REFUSAL OF PLANNING PERMISSION

APPLICATION NO. 2019/1572

Proposal Conversion of former public house into 10 no. flats.

At The Goldthorpe Hotel, Doncaster Road, Goldthorpe, Rotherham, S63 9JA

Project Goldthorpe Hotel, Doncaster Road, Goldthorpe S63 9JA			
Title Proposed floor plans			
Date 27-09-19	Scale 1:100@A1	Dwg No J19-021 A-102	Rev -
Drawn JP	Checked

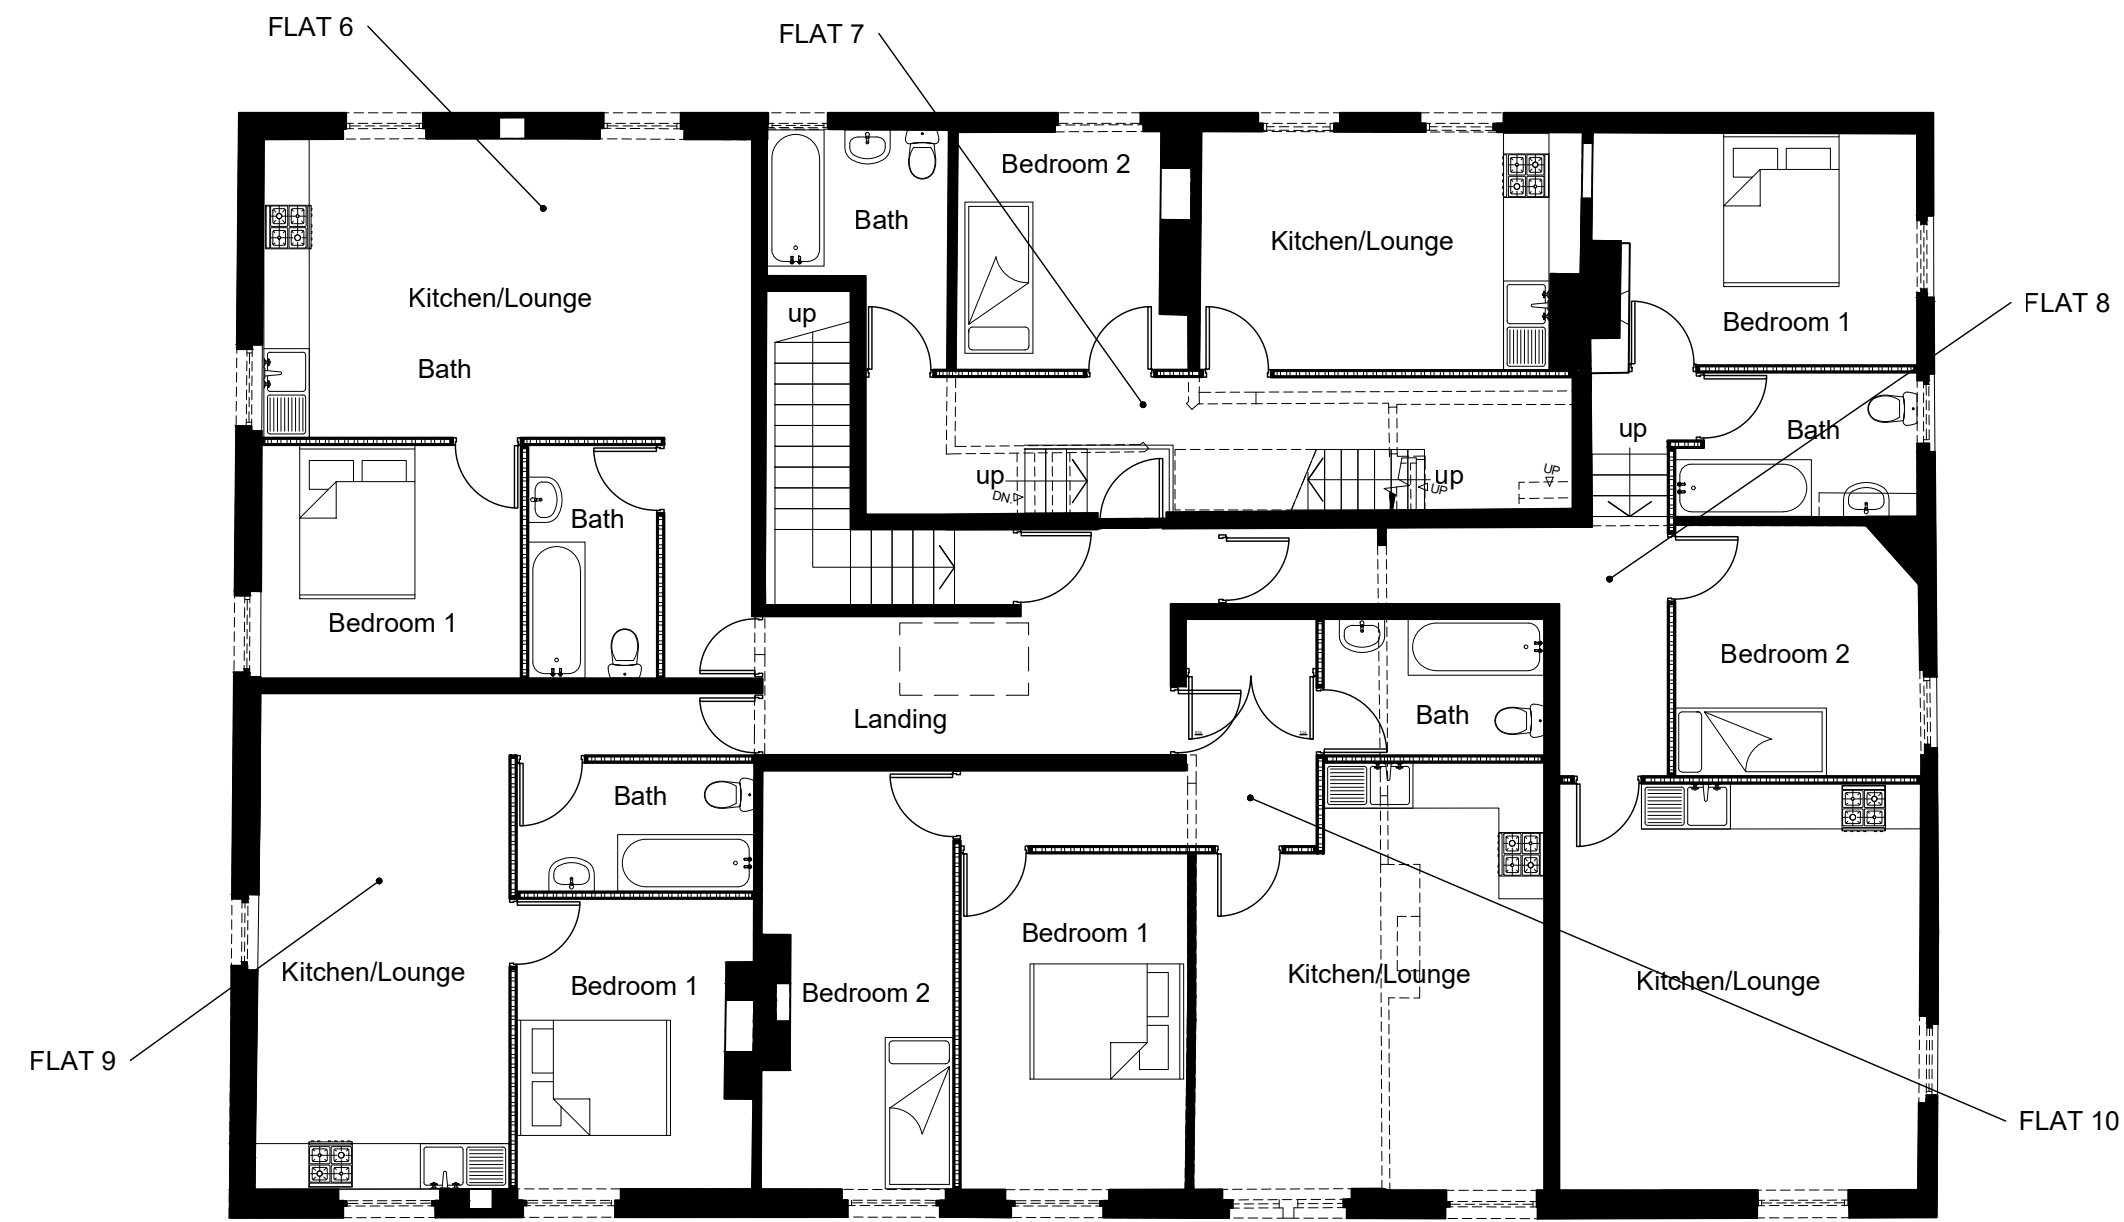
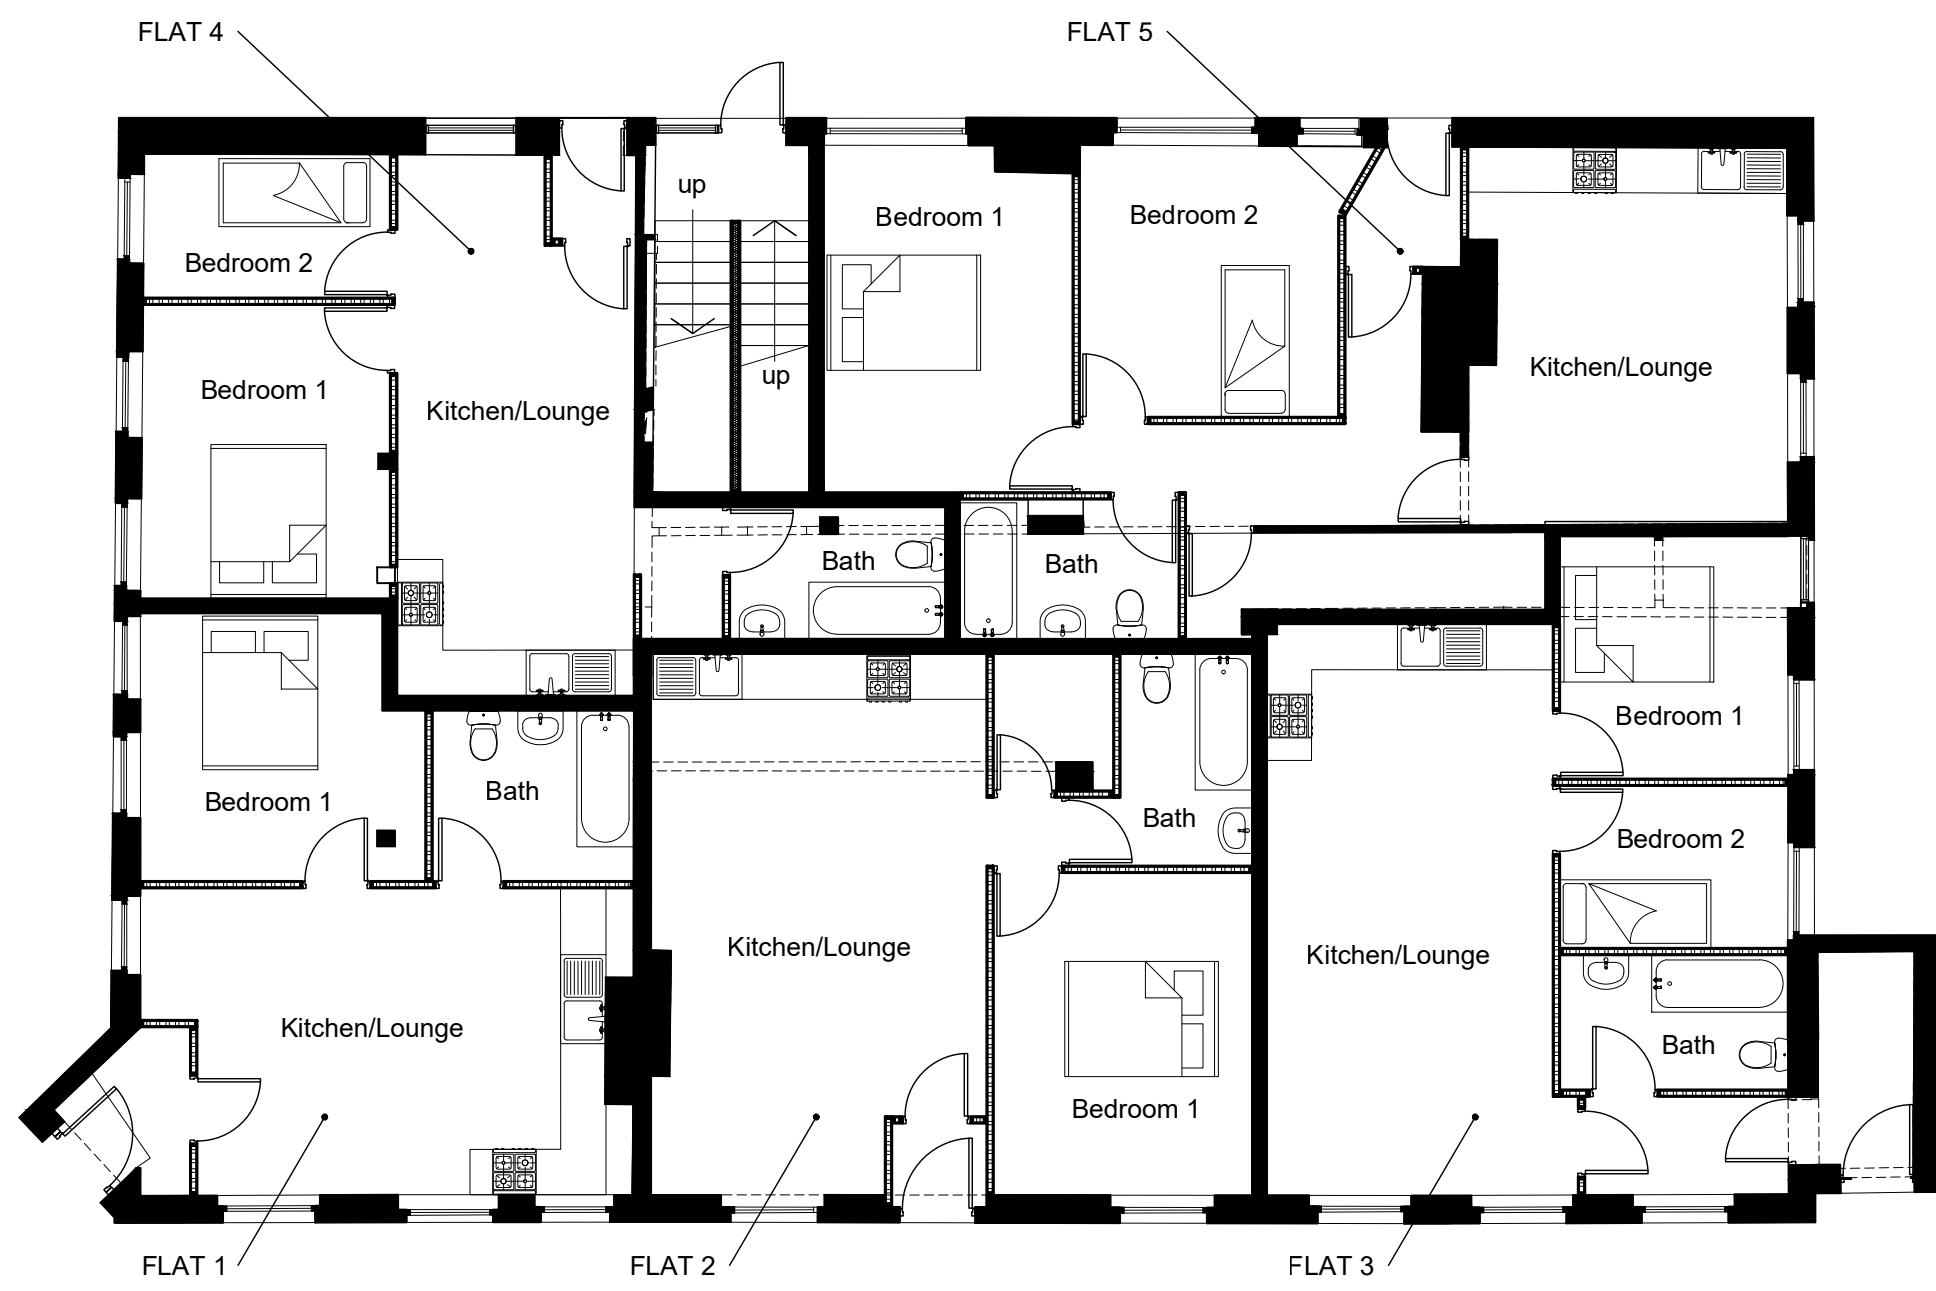
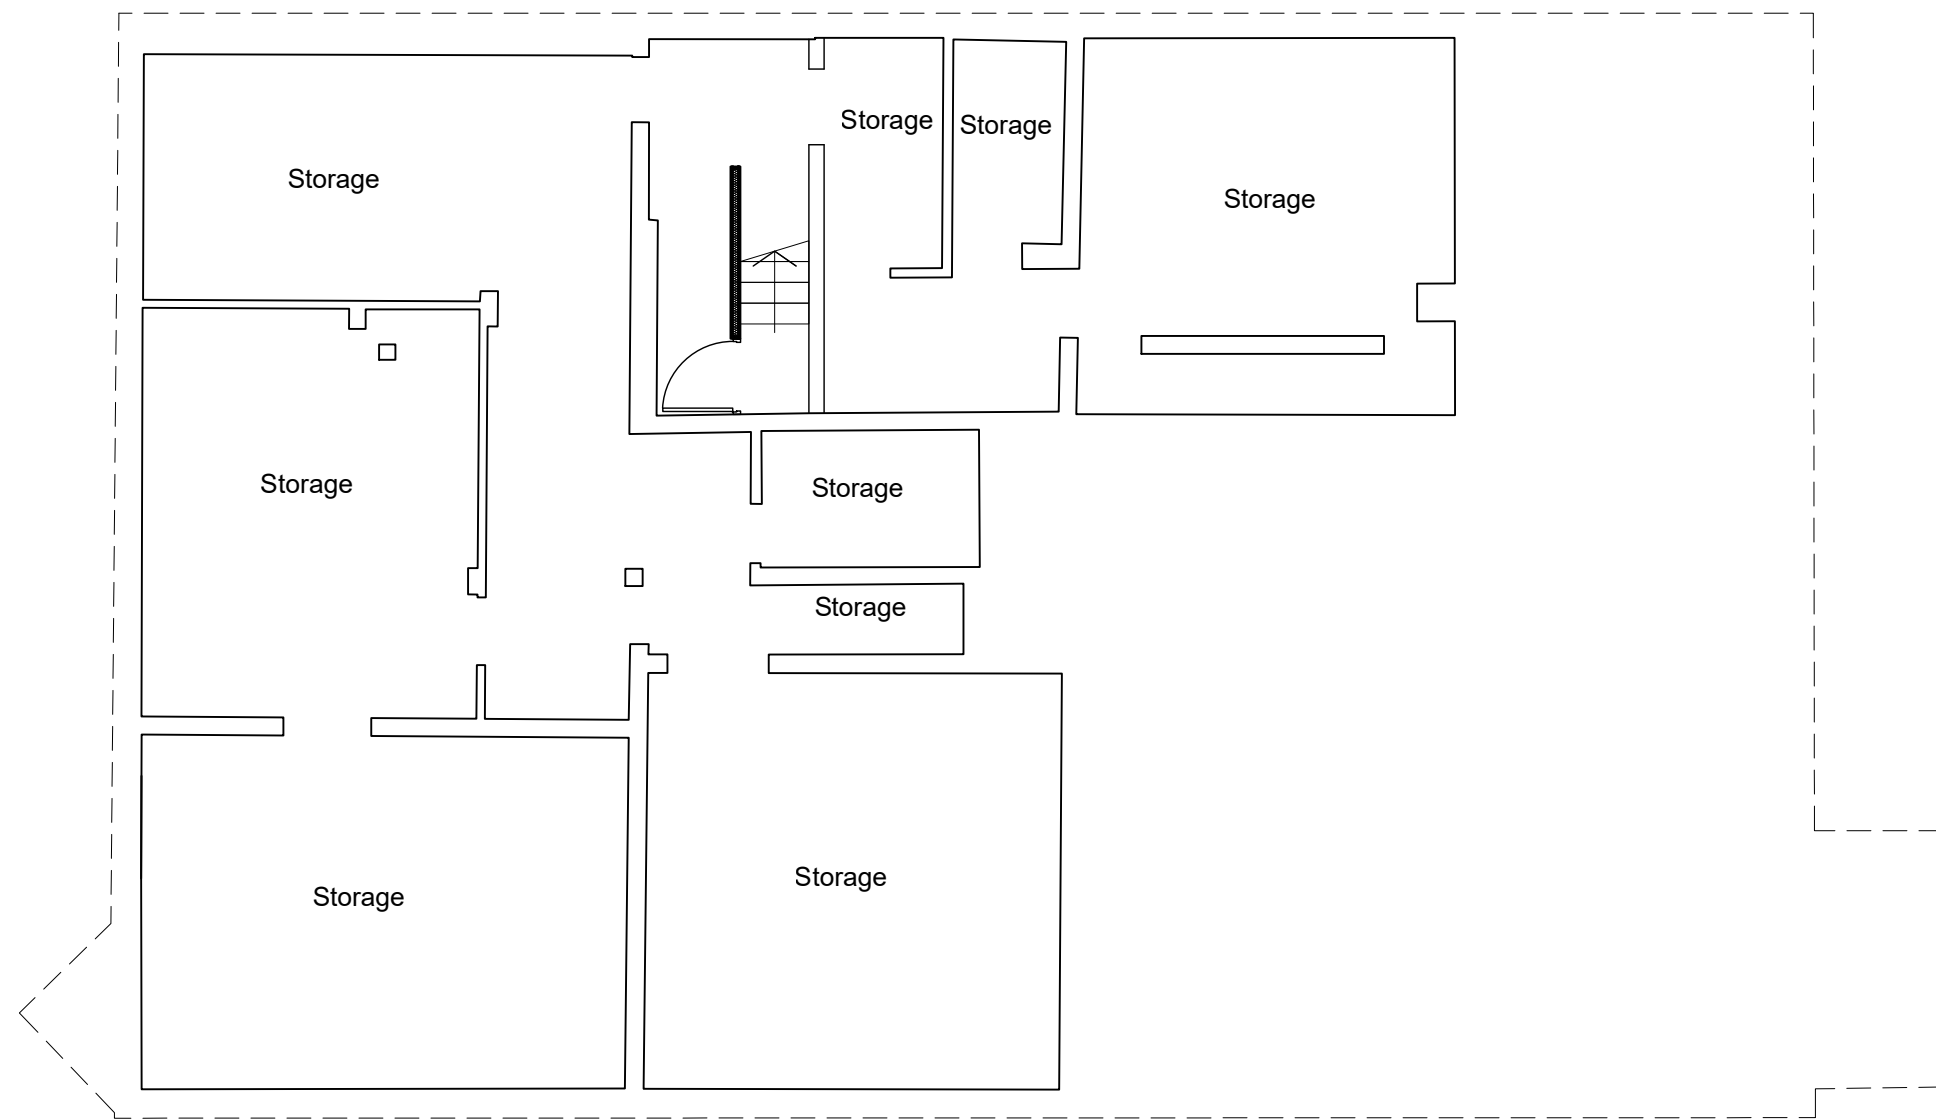
- 2 In the opinion of the Local Planning Authority, the proposed development will detrimentally impact the privacy of a neighbouring property (no. 135 Barnsley road) by virtue of the side elevation windows serving the habitable rooms of flats 1 and 9, respectively, being situated at a very close proximity (14 metres) to the existing habitable room windows located on the side elevation of no. 135. This in turn will have adversely affect the residential amenity enjoyed by this neighbouring residential property, contrary to SPD: Design of Housing Development and Local Plan Policy GD1: General Development.
